Reference No: 2020/70/93674/W

Site Address: Gill Birks Farm, 5, Gill Birks, Meltham, Holmfirth, HD9 4DZ

Description: Variation of condition 2. (plans and specifications) on previous permission no. 2020/91235 for erection of extension and alterations to attached garage/workshop to extend living accommodation (Listed Building within a Conservation Area)

Officer Report 2020/93674

Roof Plan 1:100

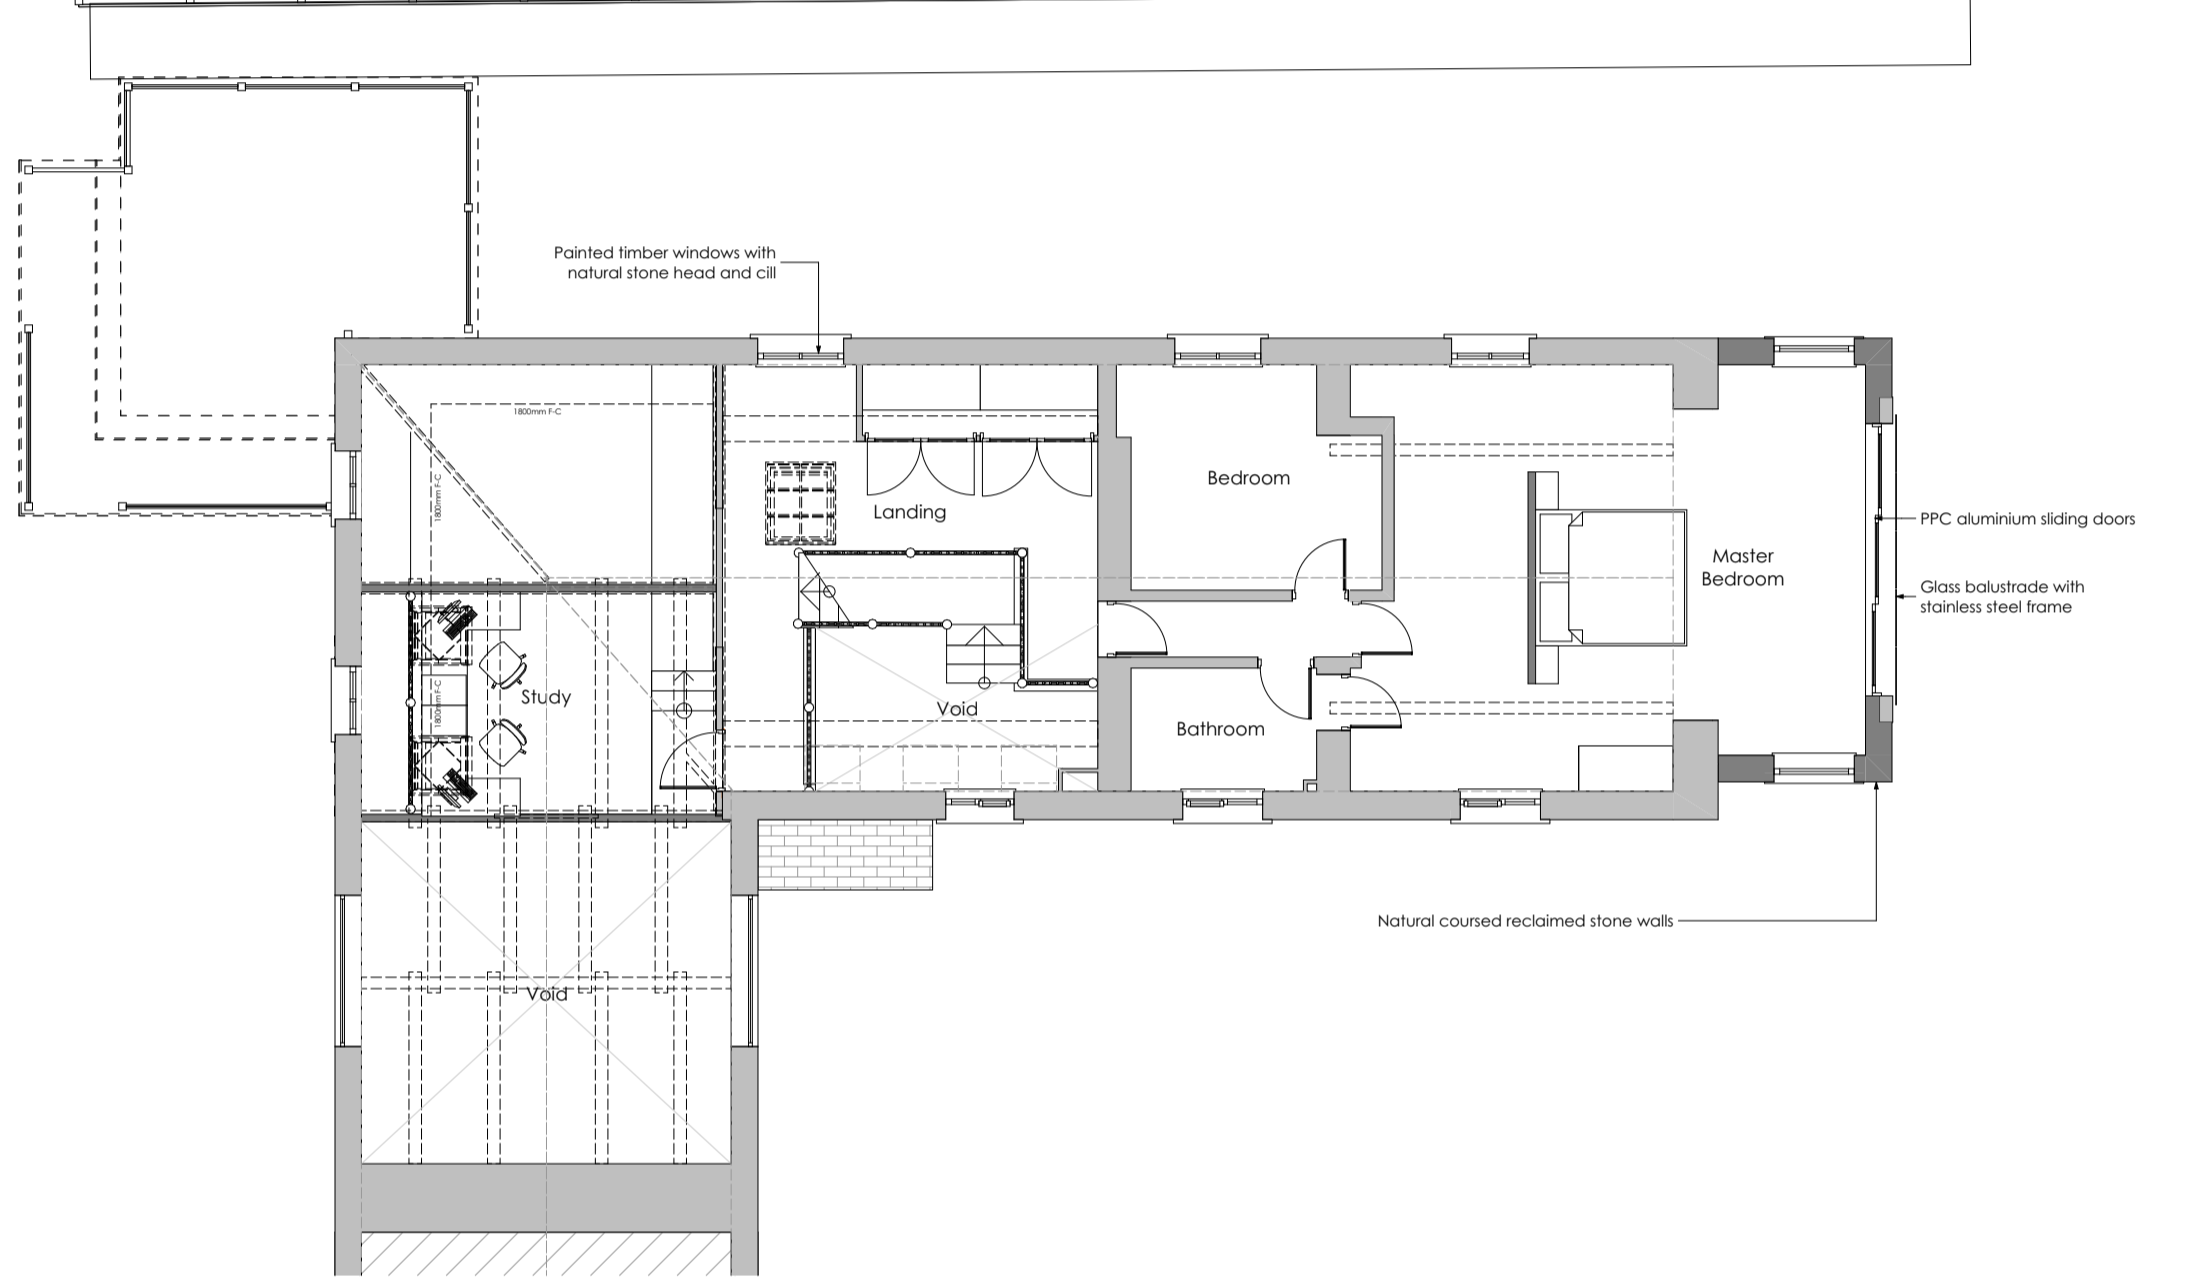
It is considered that the other changes (including the canopy porch) are modest in scale and would respect the character of the building. The rooflights must be of conservation style (flush or recessed) – this can be conditioned.

4. The hereby approved rooflights shall be of a conservation style and shall be installed flush with the roofline so they do not protrude above.

E-01 Elevation 1:100

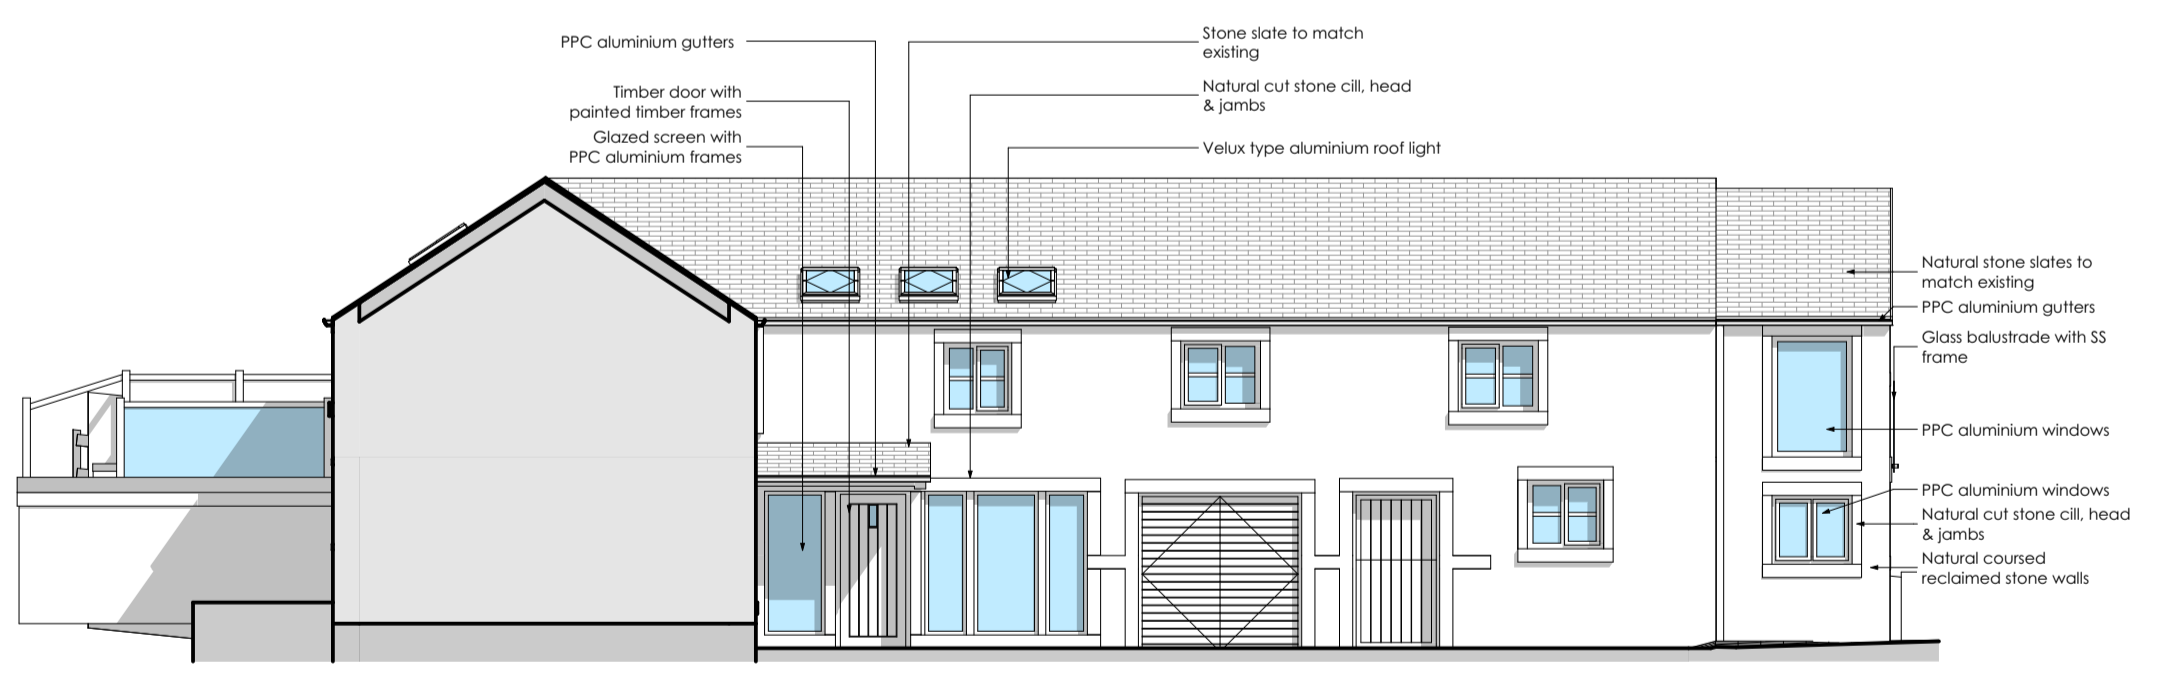
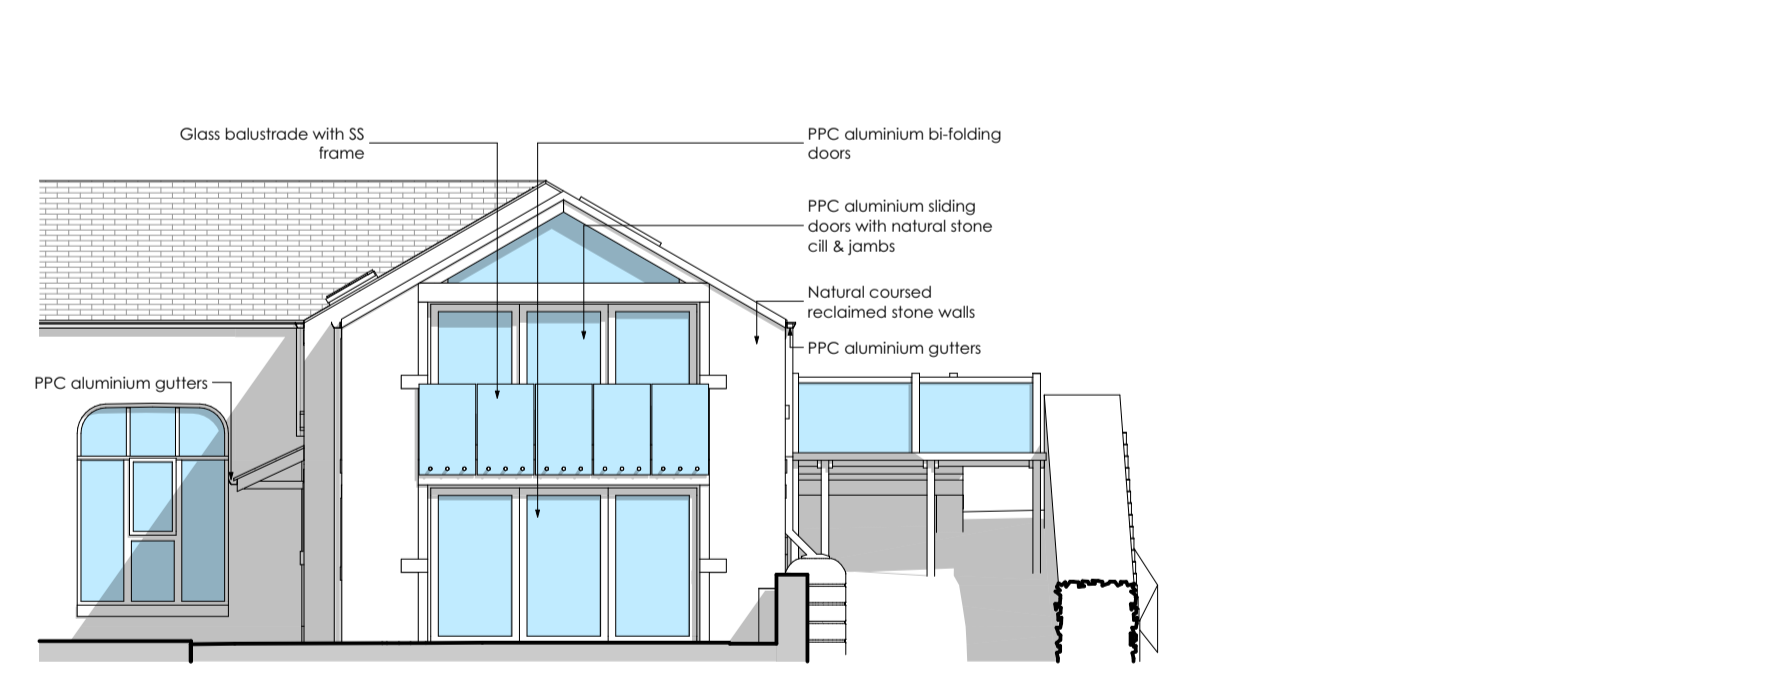
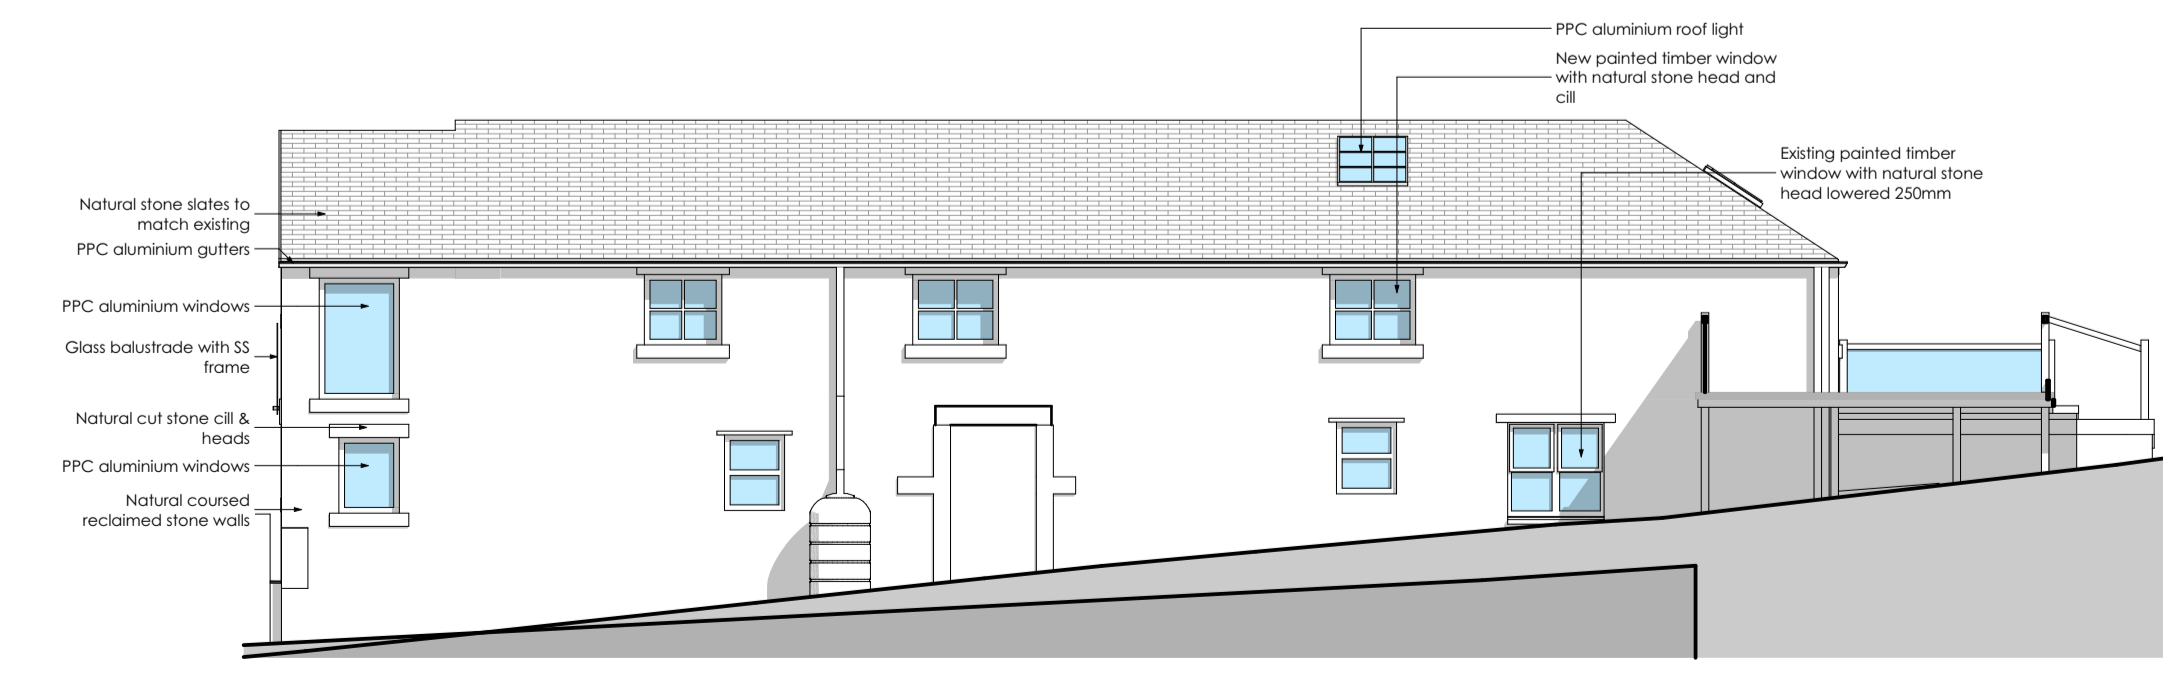
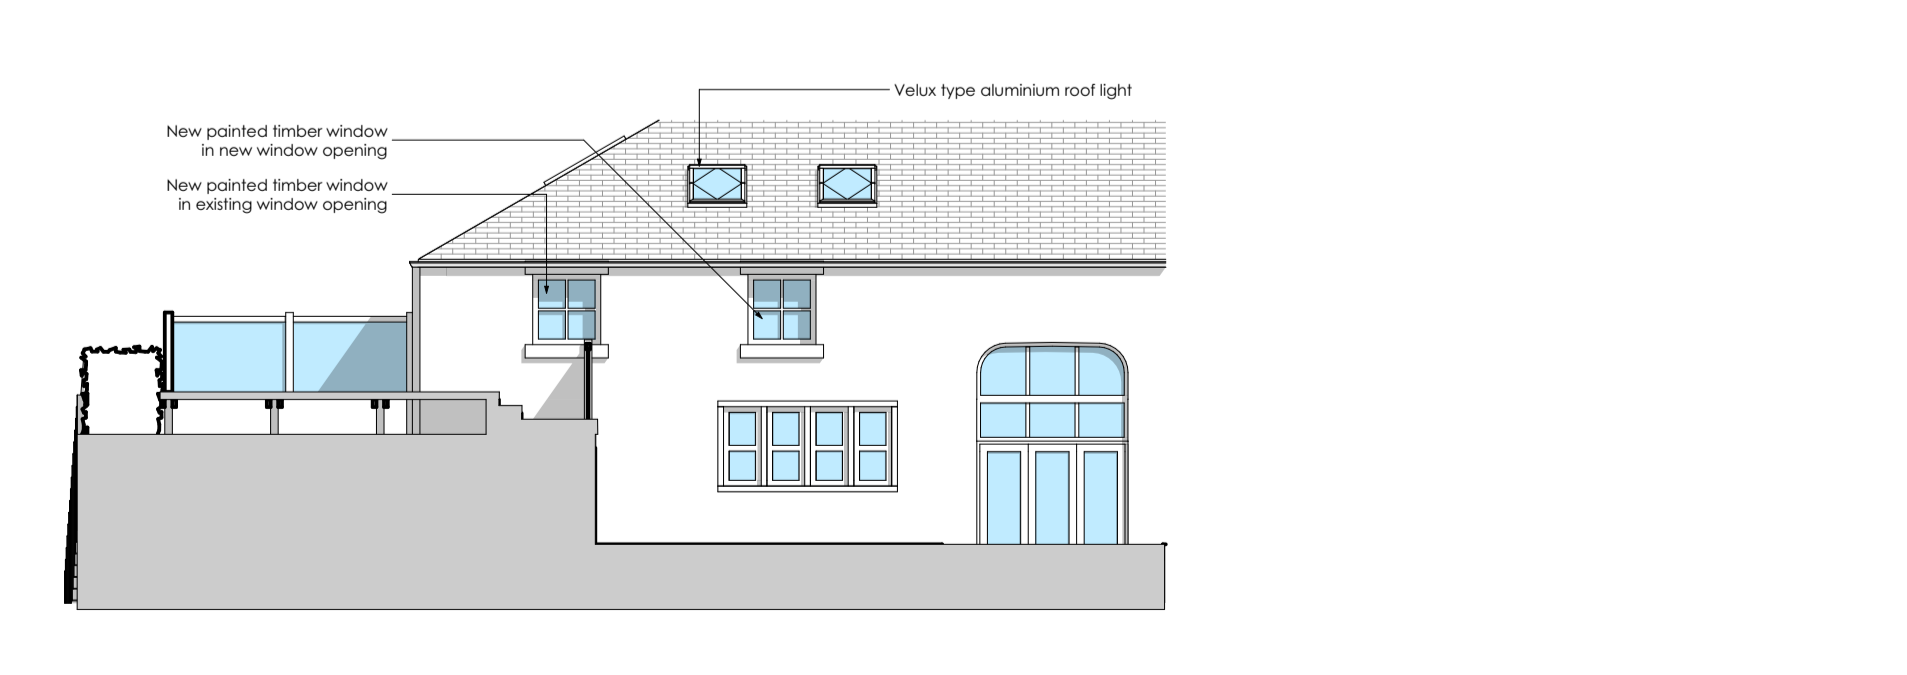
The proposal has been modified during the application process; the pattern of glazing divisions in the northern elevation has been changed so that the ground and first floors match each other and the porch changed from a solid structure to a canopy.

It is considered that the amendments to the design of the extension would give it a more cohesive appearance. There would be more glazing in the north-facing elevation but less in the side elevations, and it is therefore considered that the east side elevation would appear more harmonious when seen in the context of the existing eastern side elevation.
